A585 Windy Harbour to Skippool Improvement Scheme

6.5.1 ES Appendix 5.1: The Inspectorate's Scoping Opinion and Response

**ES APPENDIX 5.1: THE INSPECTORATES SCOPING OPINION
AND RESPONSE**

Regulation Number:	Regulation 5(2)(a)
Planning Inspectorate Scheme Reference	TR010035
Application Document Reference	TR010035/APP/6.5.1
Author:	A585 Windy Harbour to Skippool Improvement Scheme Project Team, Highways England

Drawing Title **ENVIRONMENTAL STATEMENT REGULATION 5(2)(a) AIR QUALITY: AIR QUALITY STUDY AREA**

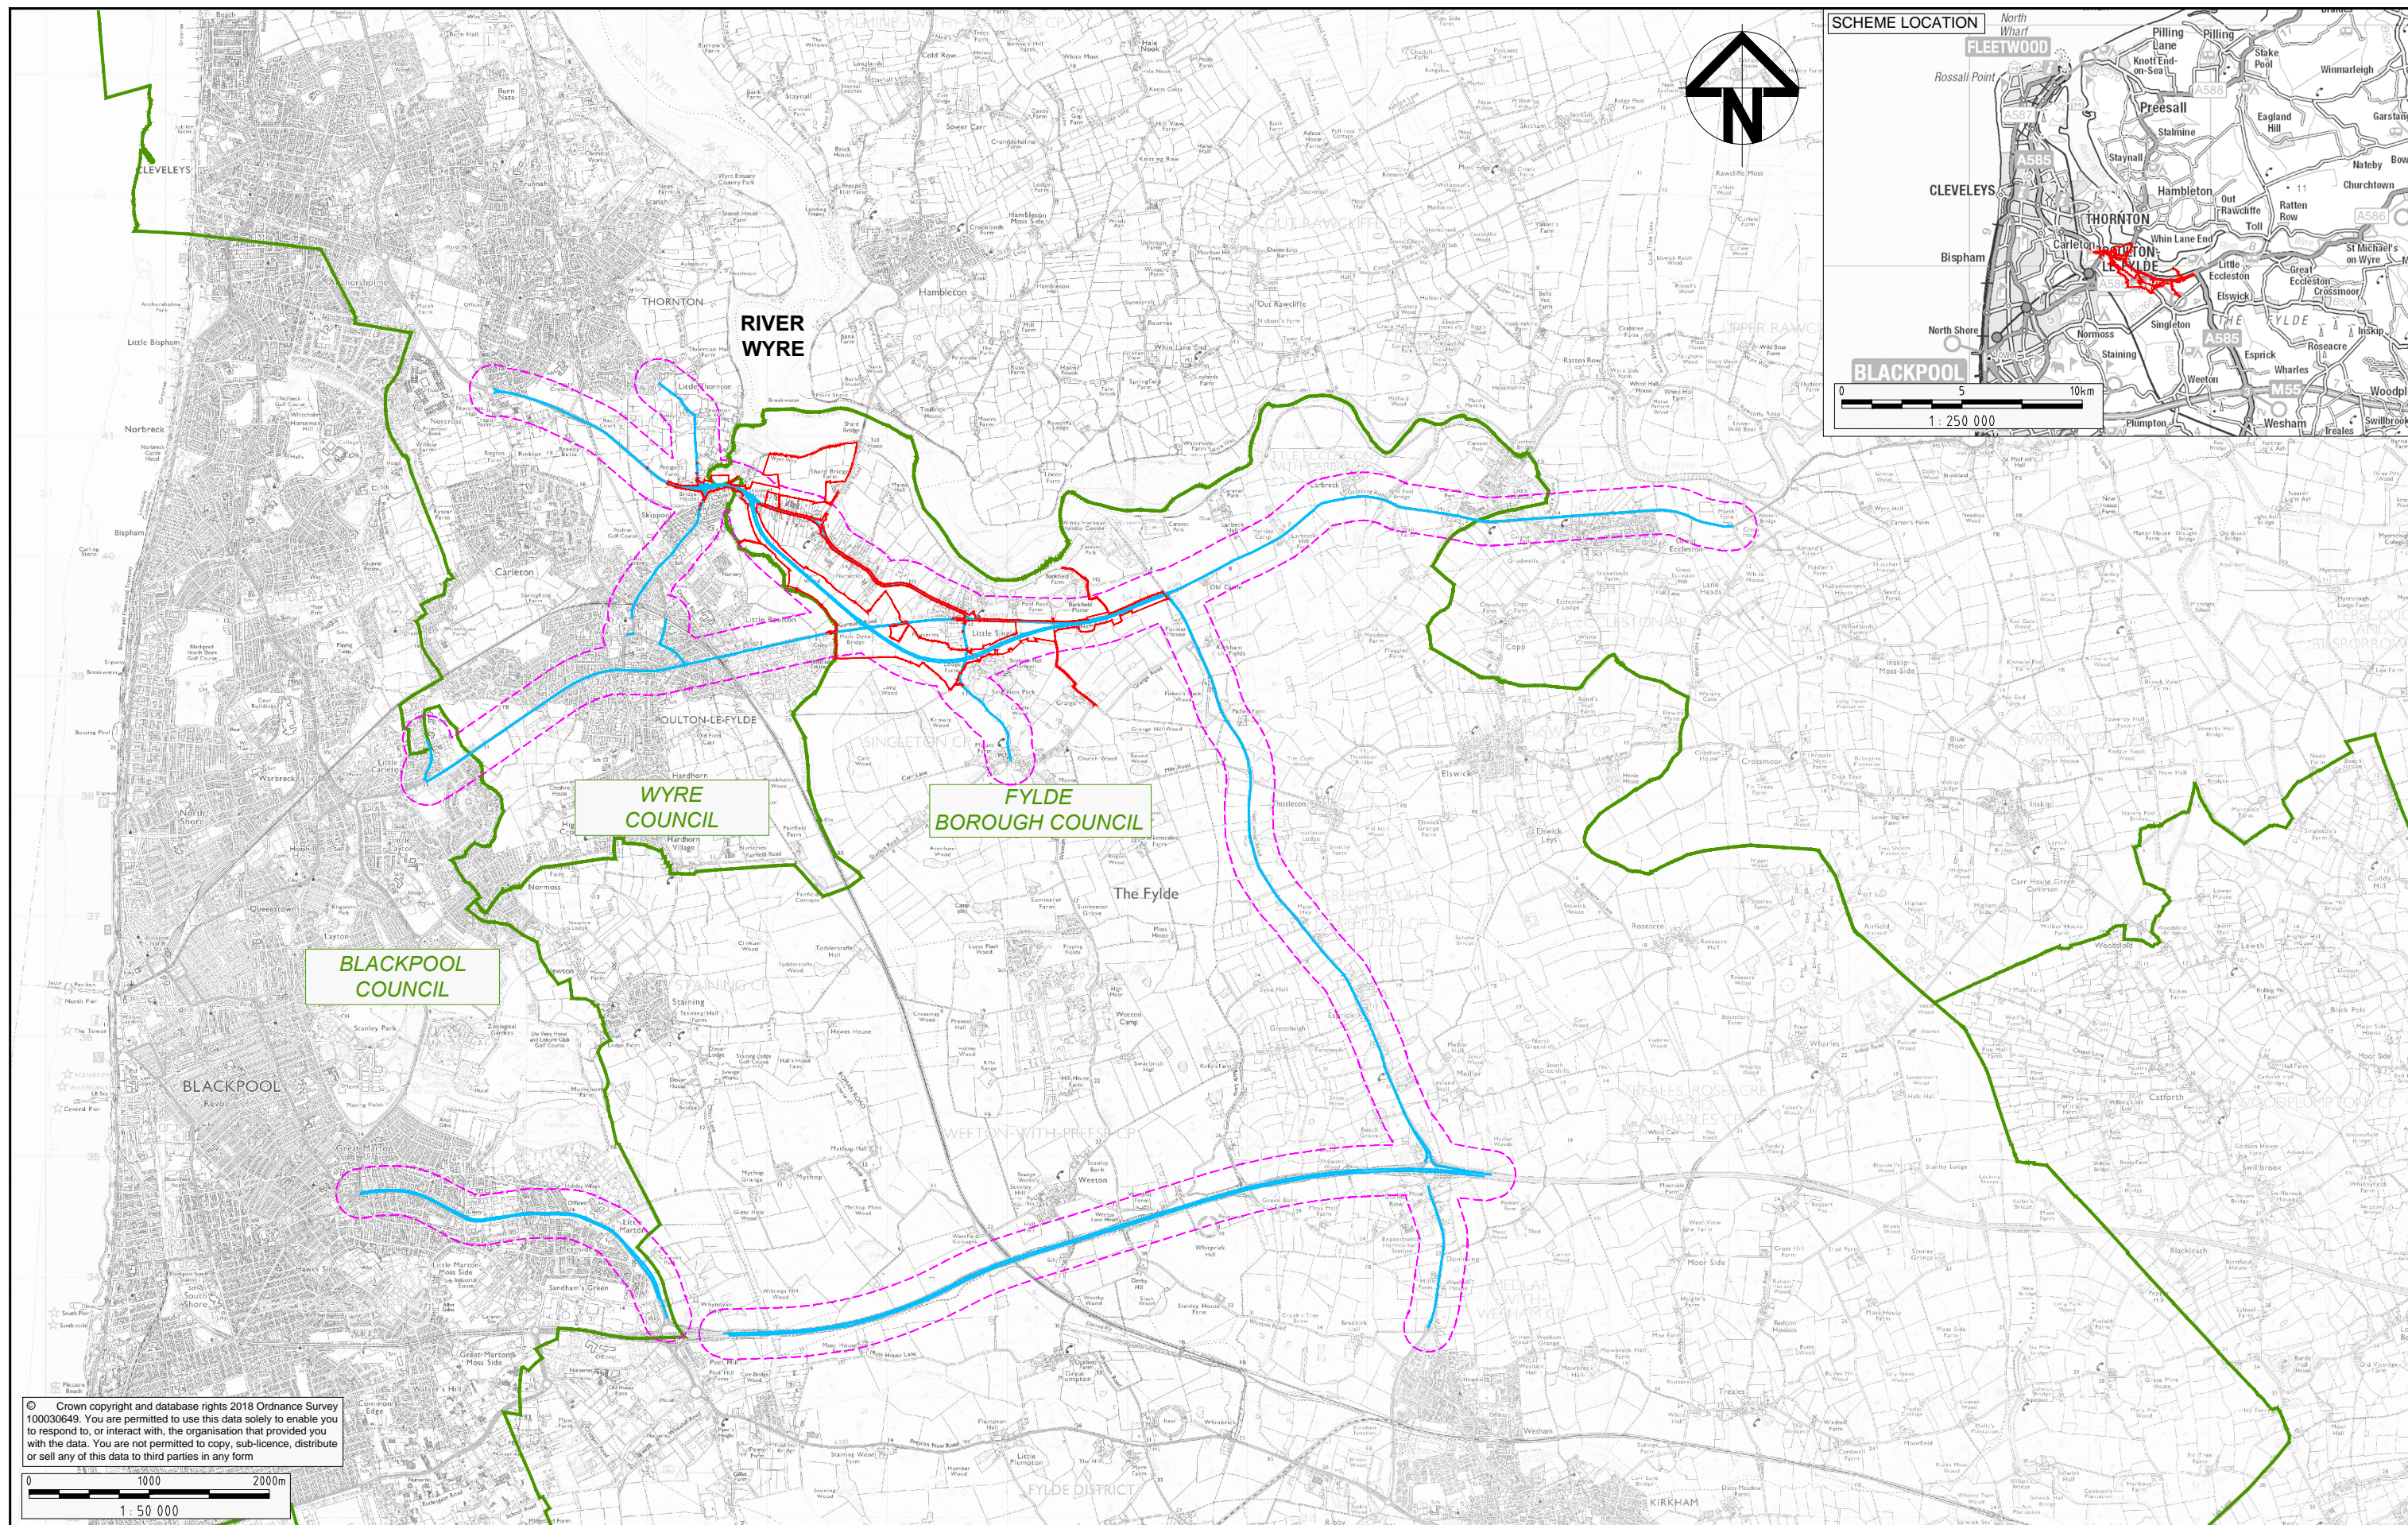
7.2.1	Study area	The extent of the study area for the assessment should be illustrated on a plan in the ES.	The affected road network is presented on Figure 6.1 (document reference TR010035/APP/6.6).
